FP 170 15 DOC 114 Felpham Way Supplementary Drainage Information

Further to our recent resubmission we enclose our drawing 1430 P 04 Rev D incorporating additional soakaway information together with details 1430 P 25 Supplementary sections for permeable paving and proprietary crate soakaway system.

Subject: FW: FP/127/15/DOC 114 Felpham way

Title
Drainage Supplementary Information

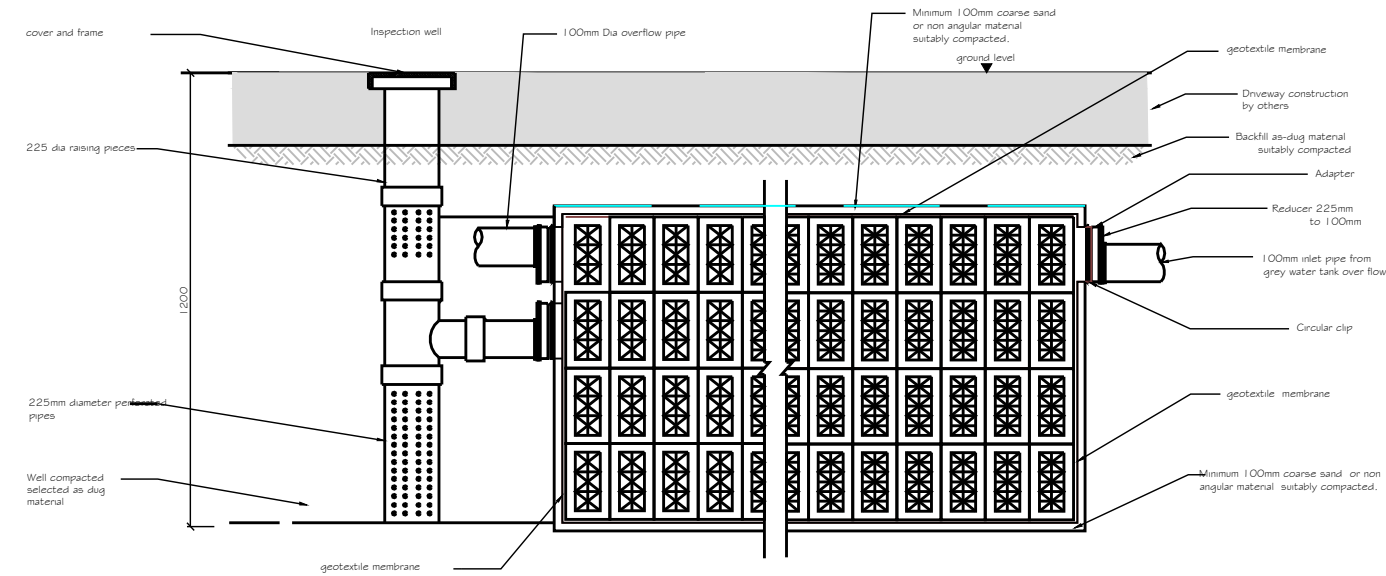
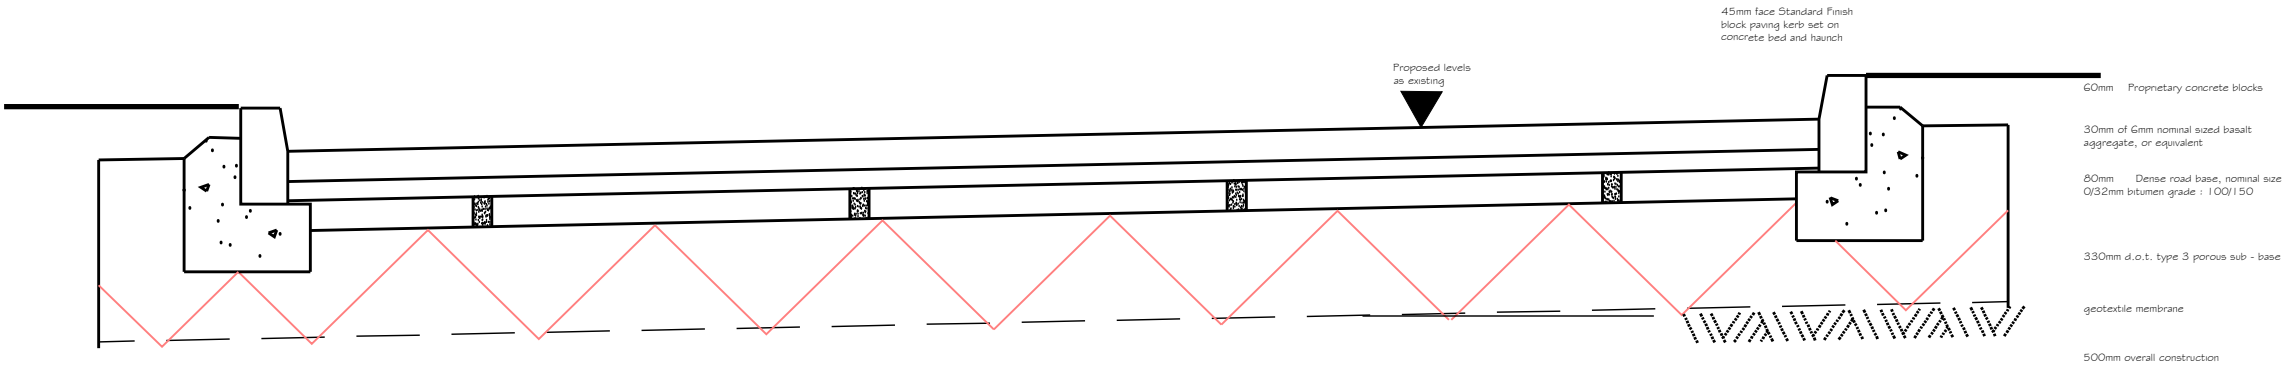
I would suggest that approximately equal soakaway storage is provided on both sides of the roof ridge. Perhaps crate soakaways (dimension 2x1x0.8m) are used in both gardens, linked to the rainwater harvesting etc by overflows; and that a further two of the same dimensions are positioned on the other side of the building. The base of the soakaways should be no lower than 1.2m below ground level, and it would be useful to have some kind of construction drawings for the surface water drainage system, including the permeable paved areas. It may be sensible to have high level overflows from the soakaways to each other and also the permeable paved areas.

Title
Site Plan

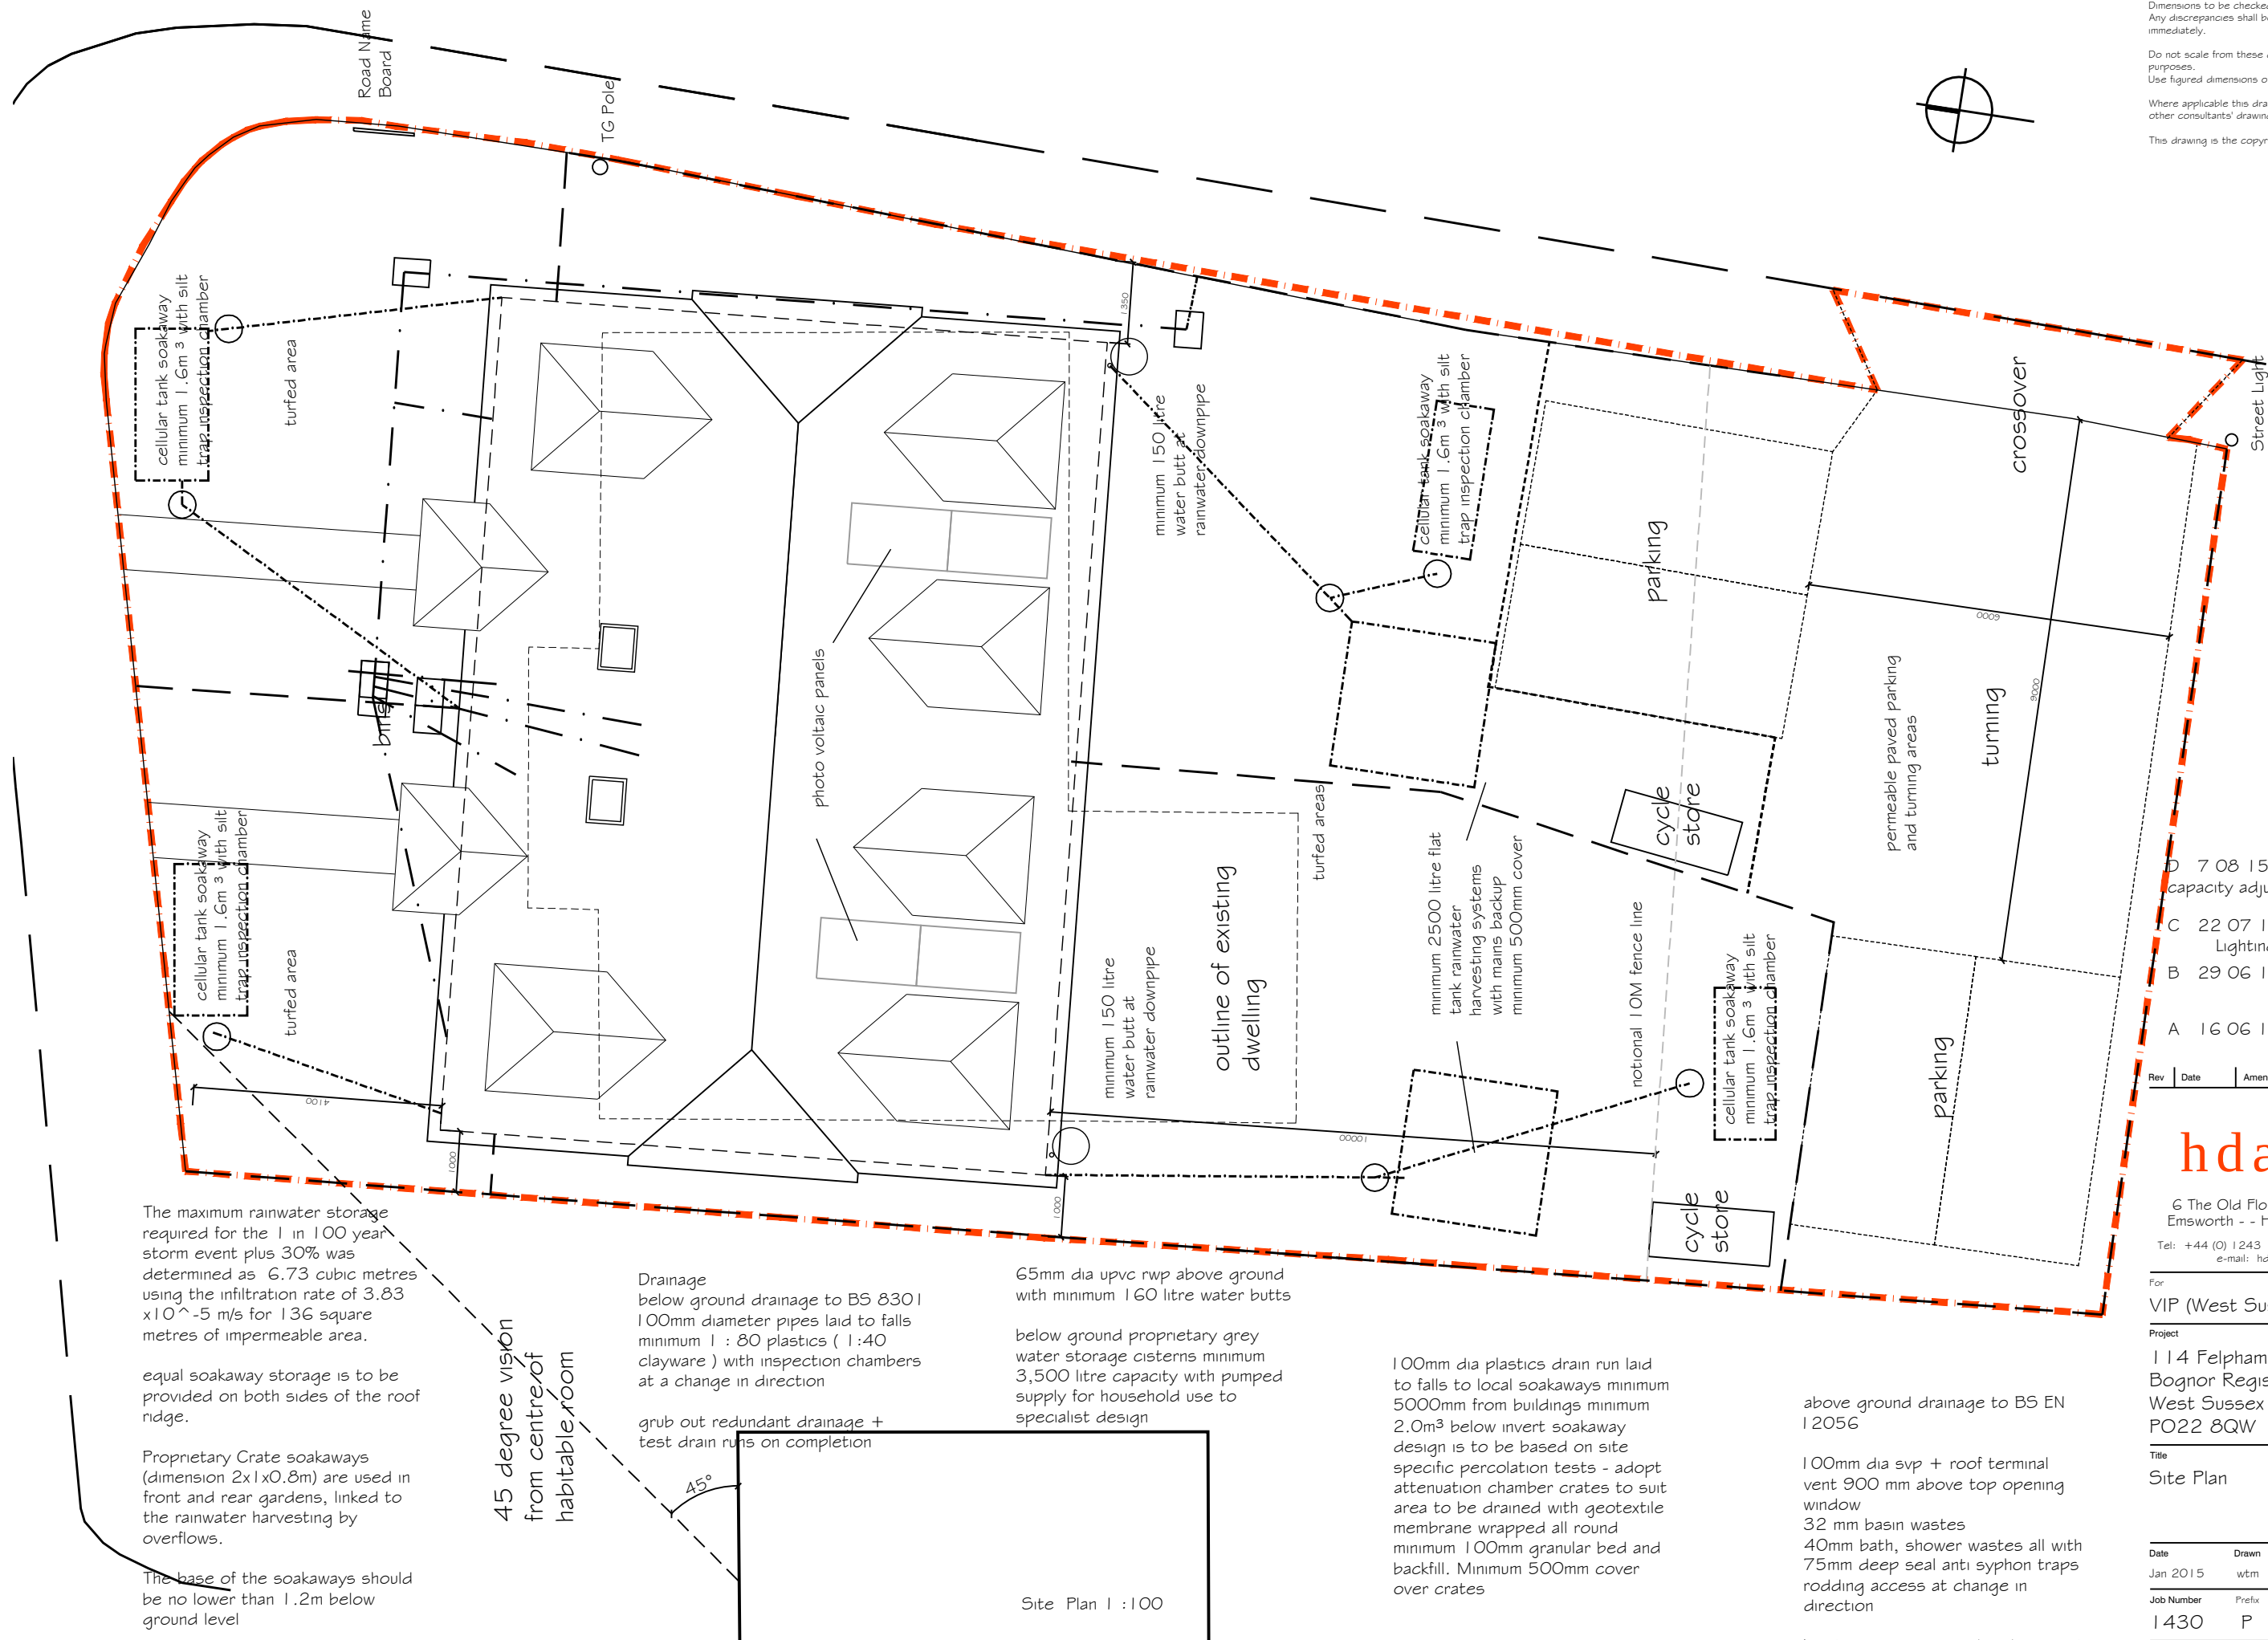
I checked the calculated infiltration rate and found it to be 3.83×10^{-5} m/s using the raw numbers supplied, rather than the 3.3×10^{-3} m/s stated. This rate would have been far too fast for the expected soil conditions at this location, and I would suggest that even the rate I calculated would be quite good for the area. However this was from the numbers supplied from the testing so we will accept the rate of 3.83×10^{-5} m/s.

I found the rest of the calculations quite confusing to follow so applied the raw data to a spreadsheet I have put together to come up with some design figures. Please note I am not willing to distribute the spreadsheet in case of any inaccuracies that could lead to liability issues. The maximum storage required for the 1 in 100 year storm event plus 30% came out at 6.73 cubic metres using the infiltration rate of 3.83×10^{-5} m/s for 136 square metres of impermeable area.

Therefore more information is required to discharge the condition.
